Subject: State Significant Development at 52 Sinclair Street, Goulburn
Proposal: Warehouse Distribution Centre, Poultry Processing & rendering plant and childcare facility

Thank you for your correspondence dated 11 December 2017 requesting early input for the proposed State Significant Development Application for a warehouse distribution centre, poultry processing and rendering plant and childcare facility located at 52 Sinclair Street Goulburn (Lot 22 DP 750050).

**PROPOSED PROCESSING FACILITY
OVERALL SITE PLAN - STAGE 1 - NO CONTOURS**

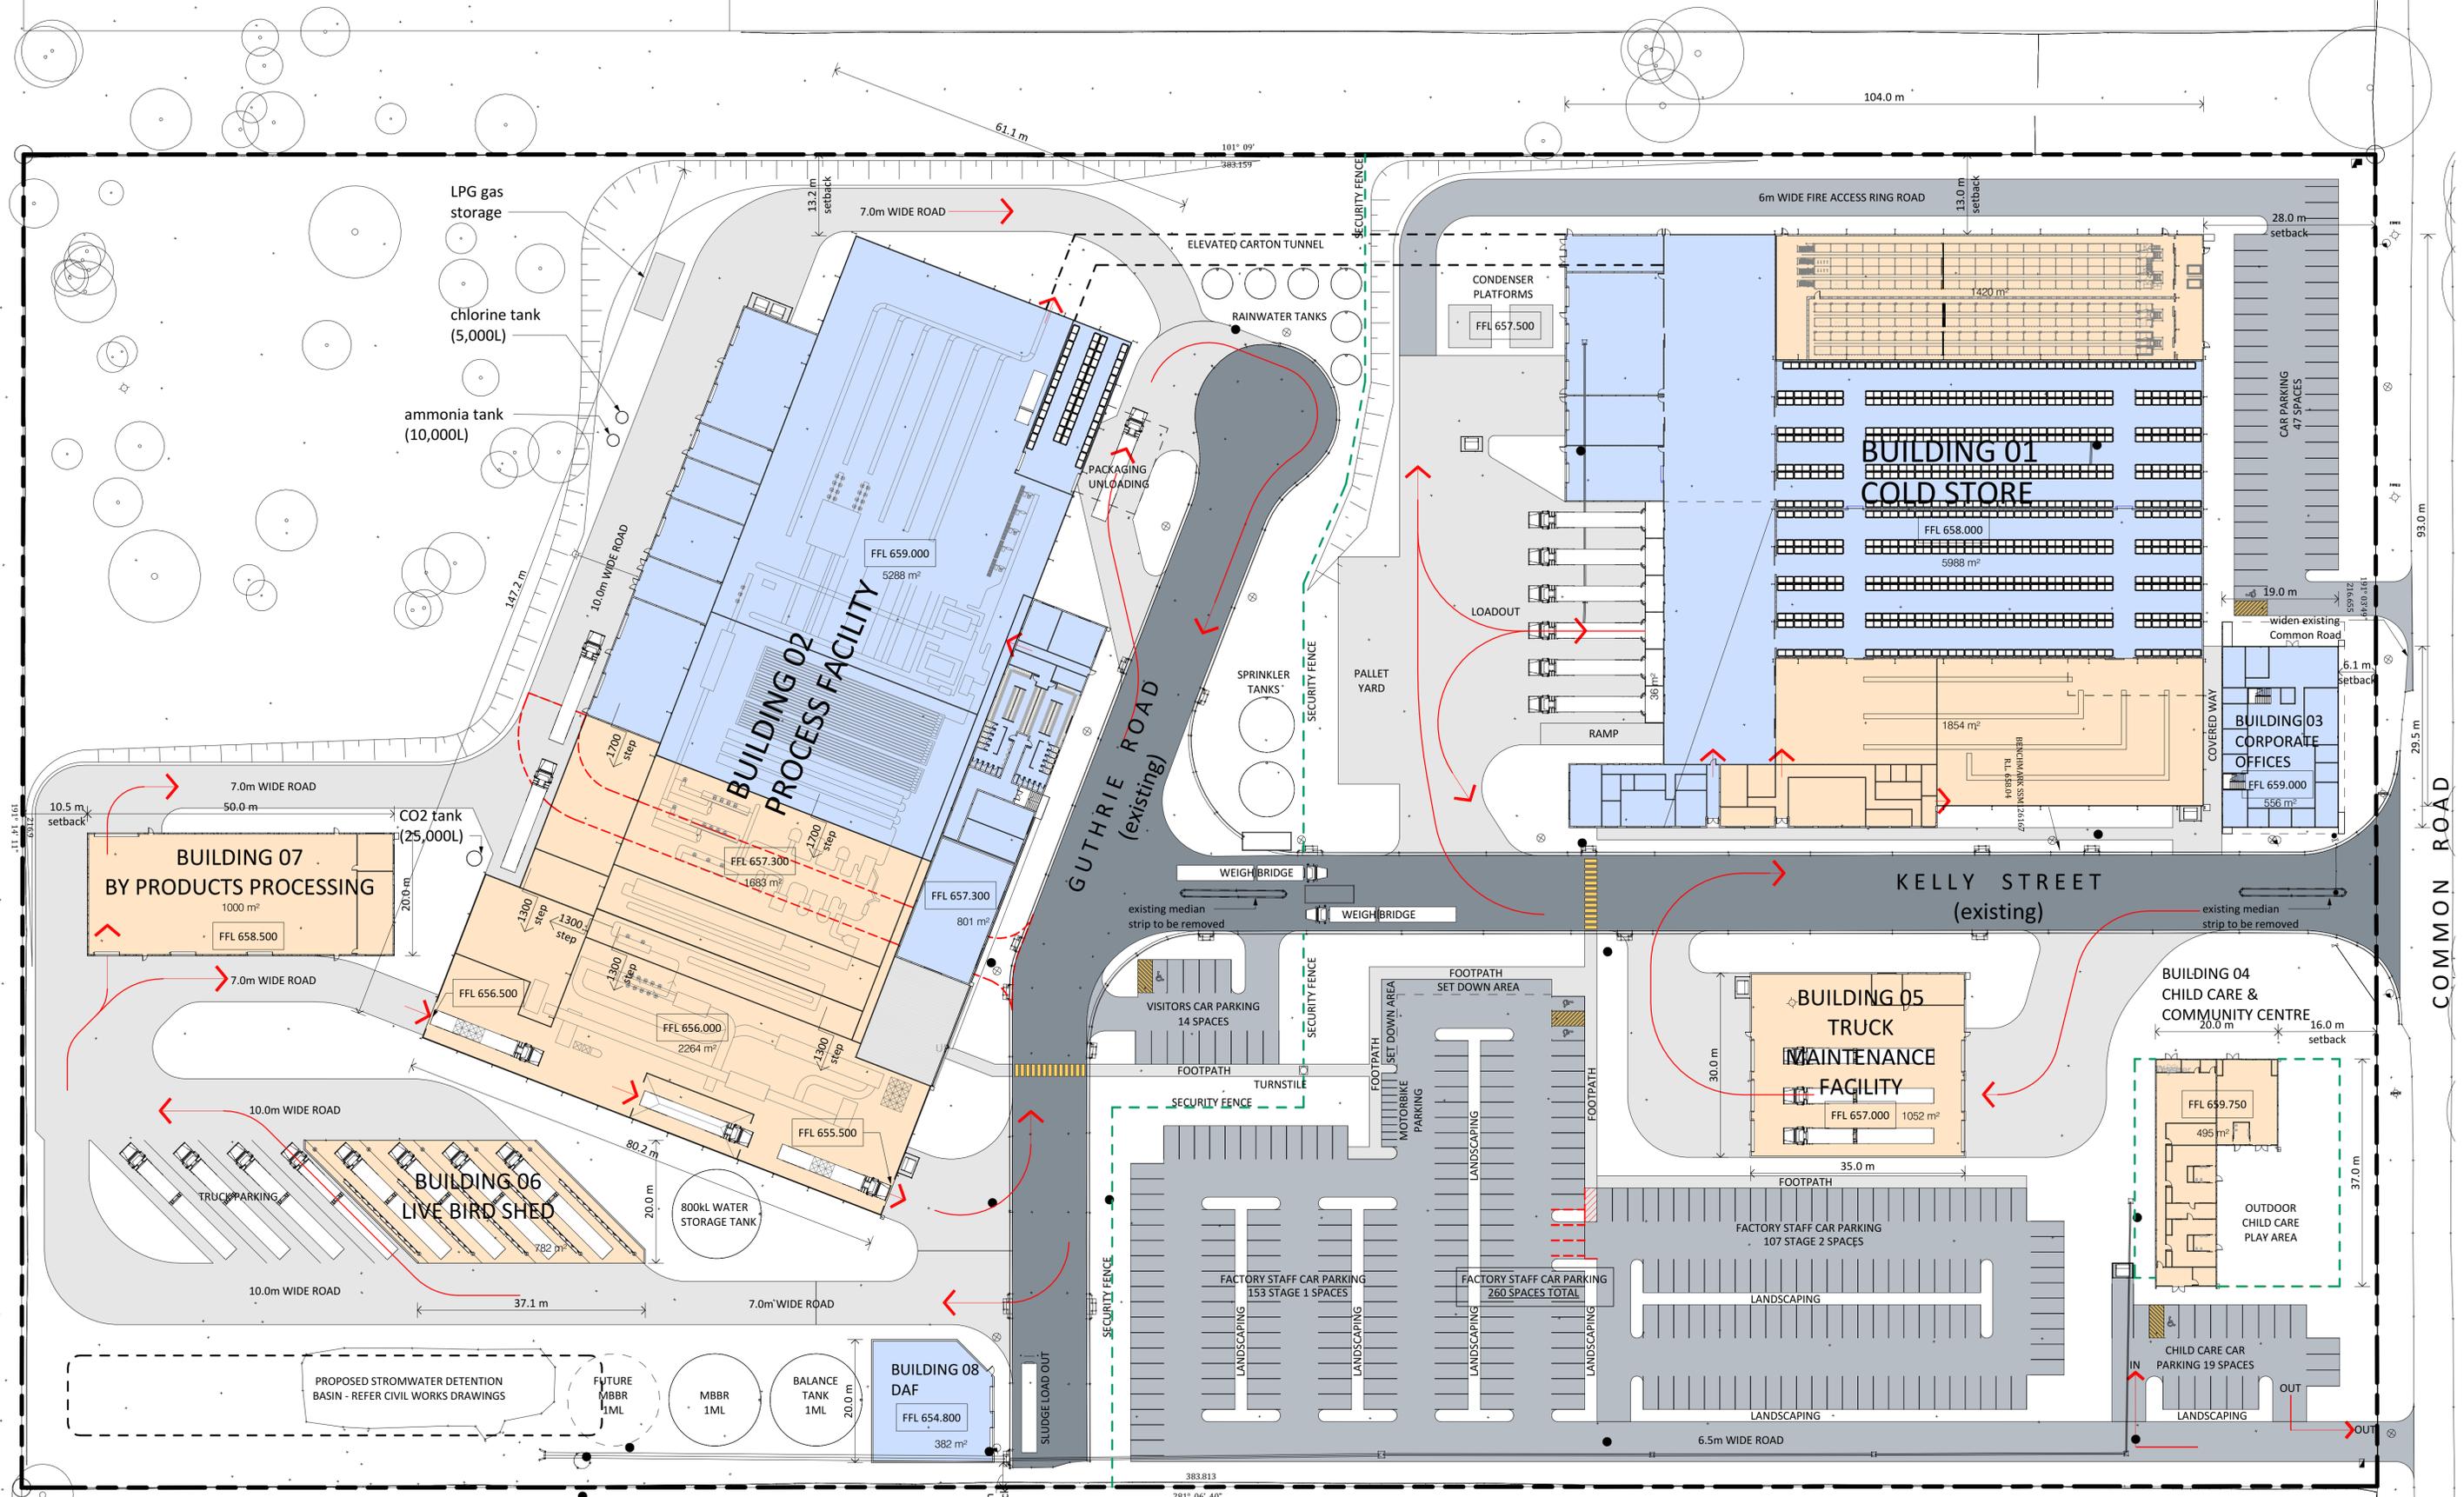
It is noted that hard stand car parking areas are proposed at the front of the site. Given the intensification that may occur within the precinct and the scale of the development proposed it would be beneficial to consider the amenity of the development from Common Street. Matters such as landscape treatment, fencing and signage should be considered.
